### MEMORANDUM

SUBJECT: Downs Short Plat SP-12-00007

**Project:** Downs Short Plat SP-12-00007

**Description:** A 2-lot short plat.

DOWN'S SHORT PLAT
PART OF SECTION 14, T. 20 N., R. 16 E., W.M.
KITITAS COUNTY, WASHINGTON

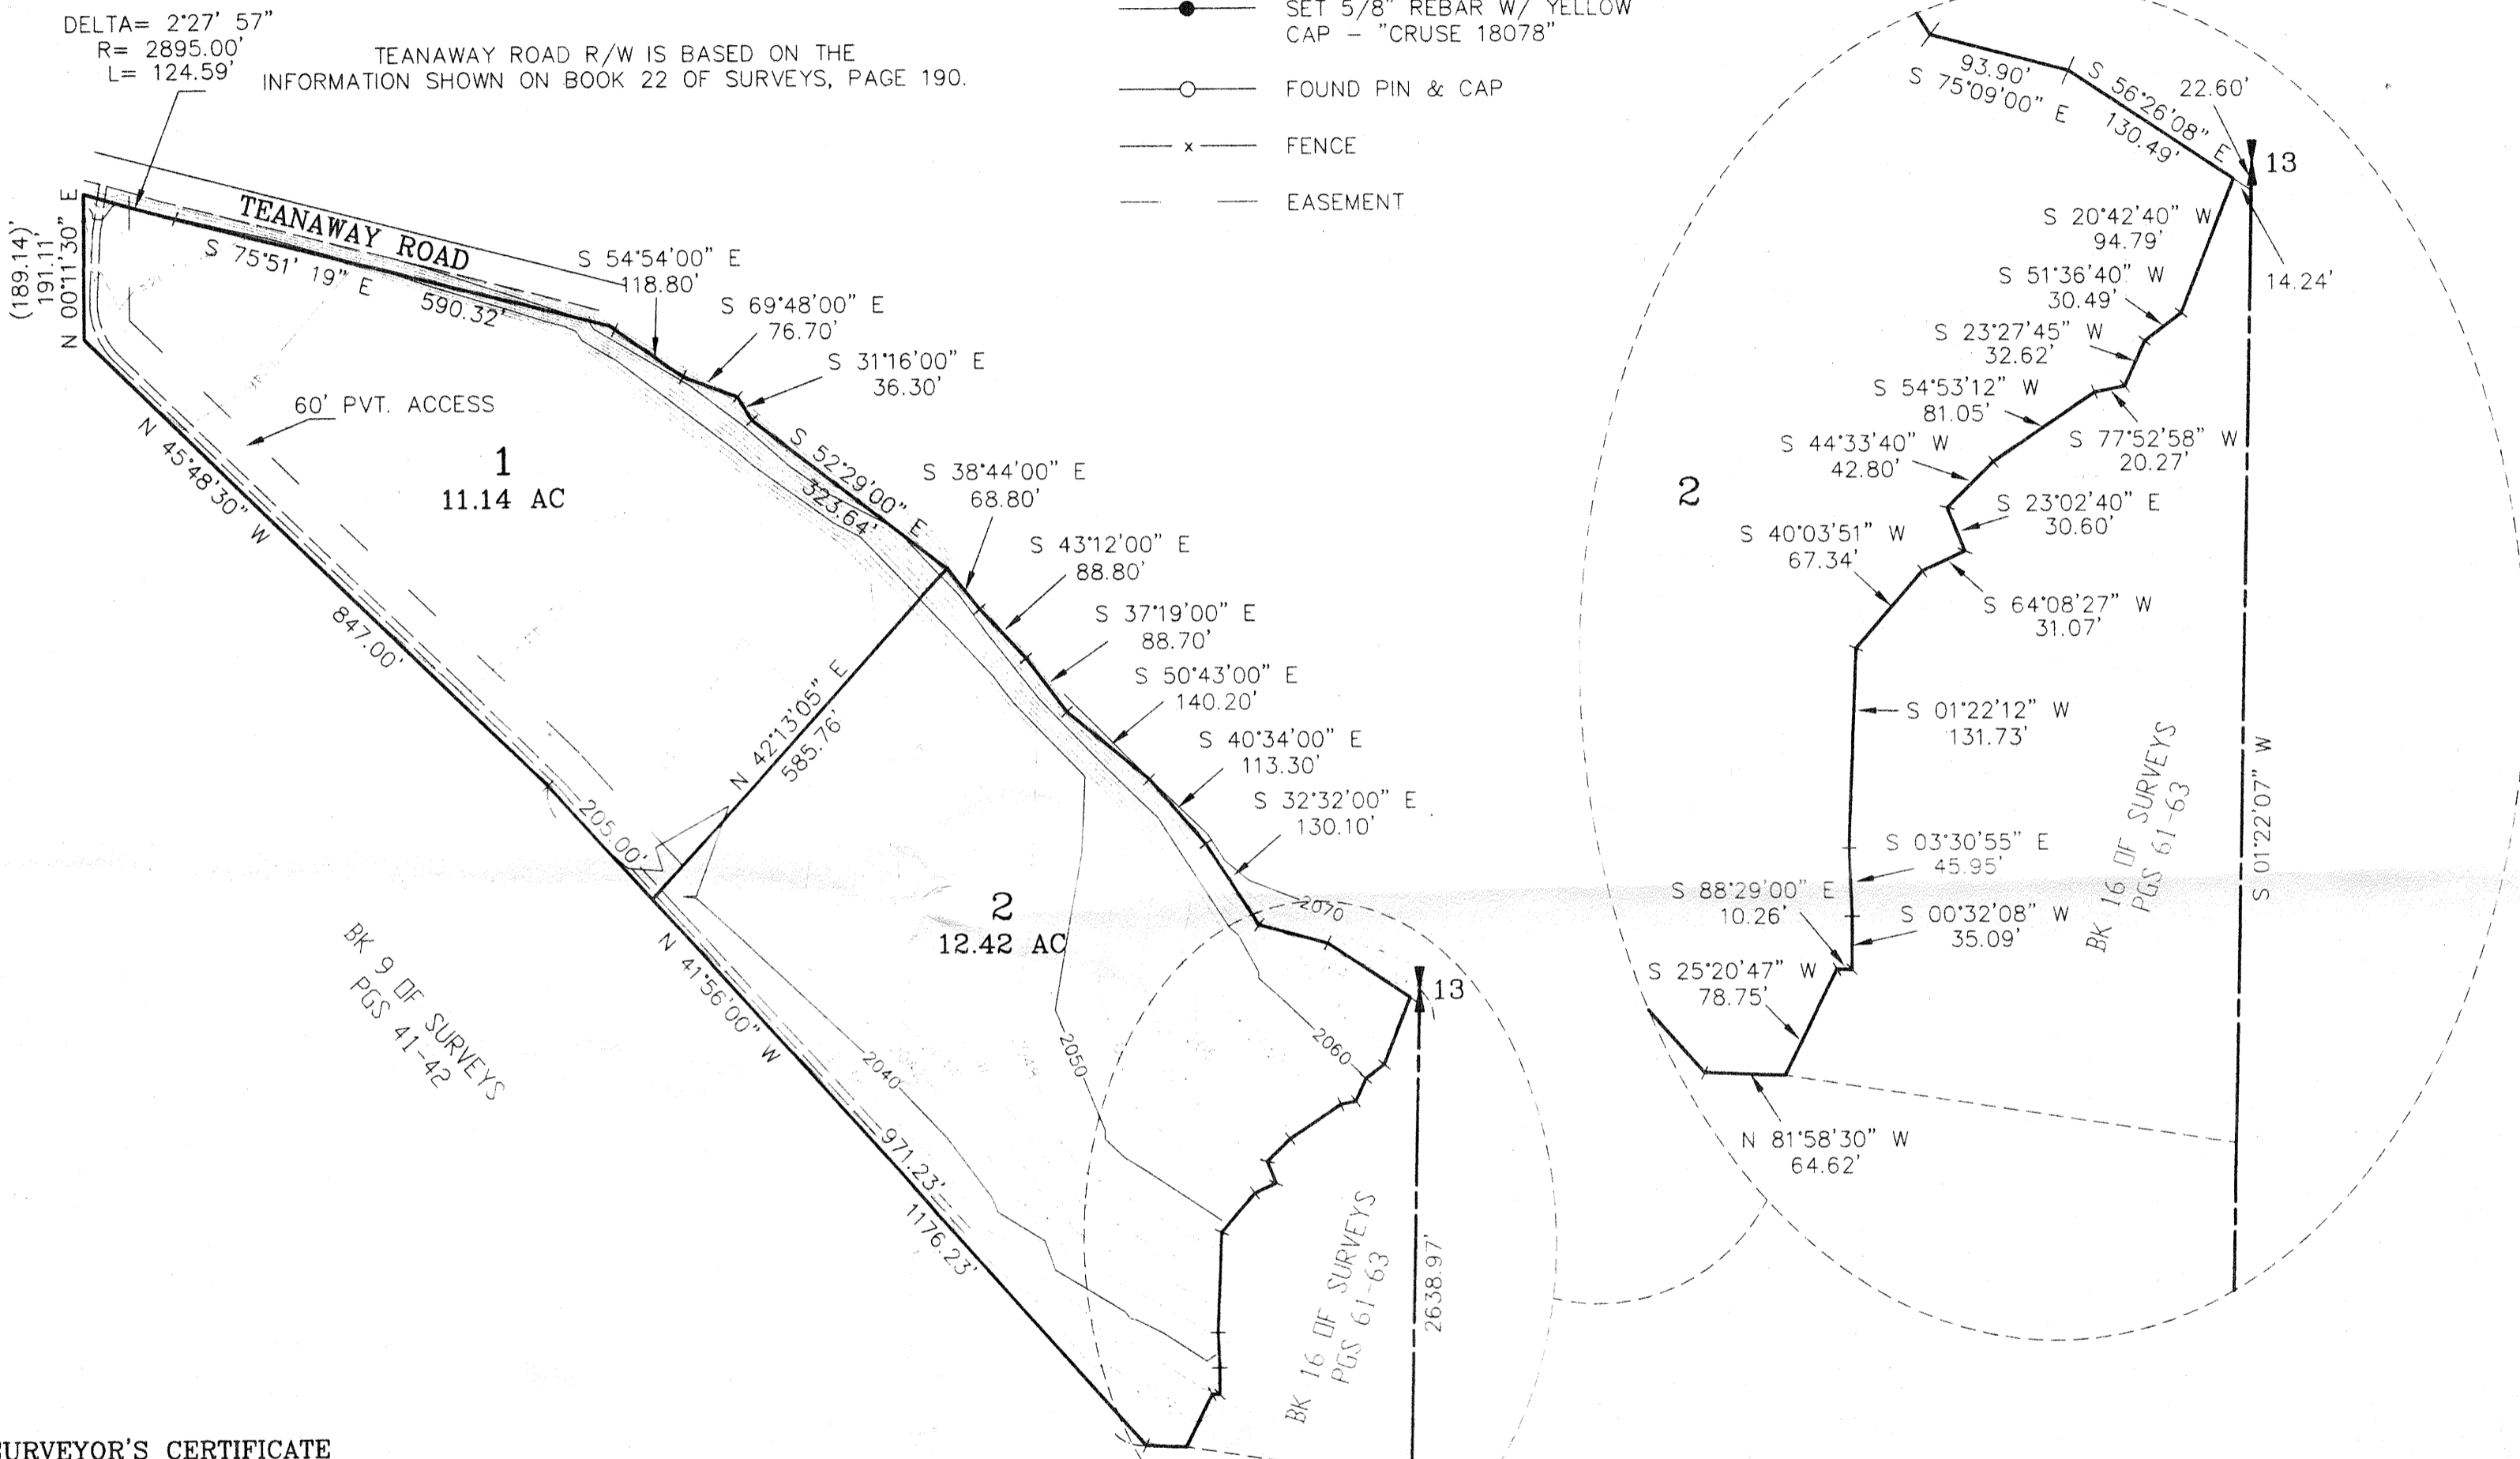
1. Access: The property may continue to use the existing approach as a joint-use driveway. If the approach serves additional lots in the future, it may need to be re-evaluated for compliance with Kittitas County Road Standards.

Joint-Use Driveway: A joint-use access shall serve no more than two tax parcels. See Kittitas County Road Standards, 9/6/05 edition.

- a. Access easements shall be a minimum of 20' wide. The roadway width shall have a minimum width of 12'.
  - b. The surface requirement is for a minimum gravel surface depth of 6".

- c. Maintenance of driveway approaches shall be the responsibility of the owner whose property they serve. The County will not maintain accesses.
  - d. Any further subdivision or lots to be served by proposed access may result in further access requirements.
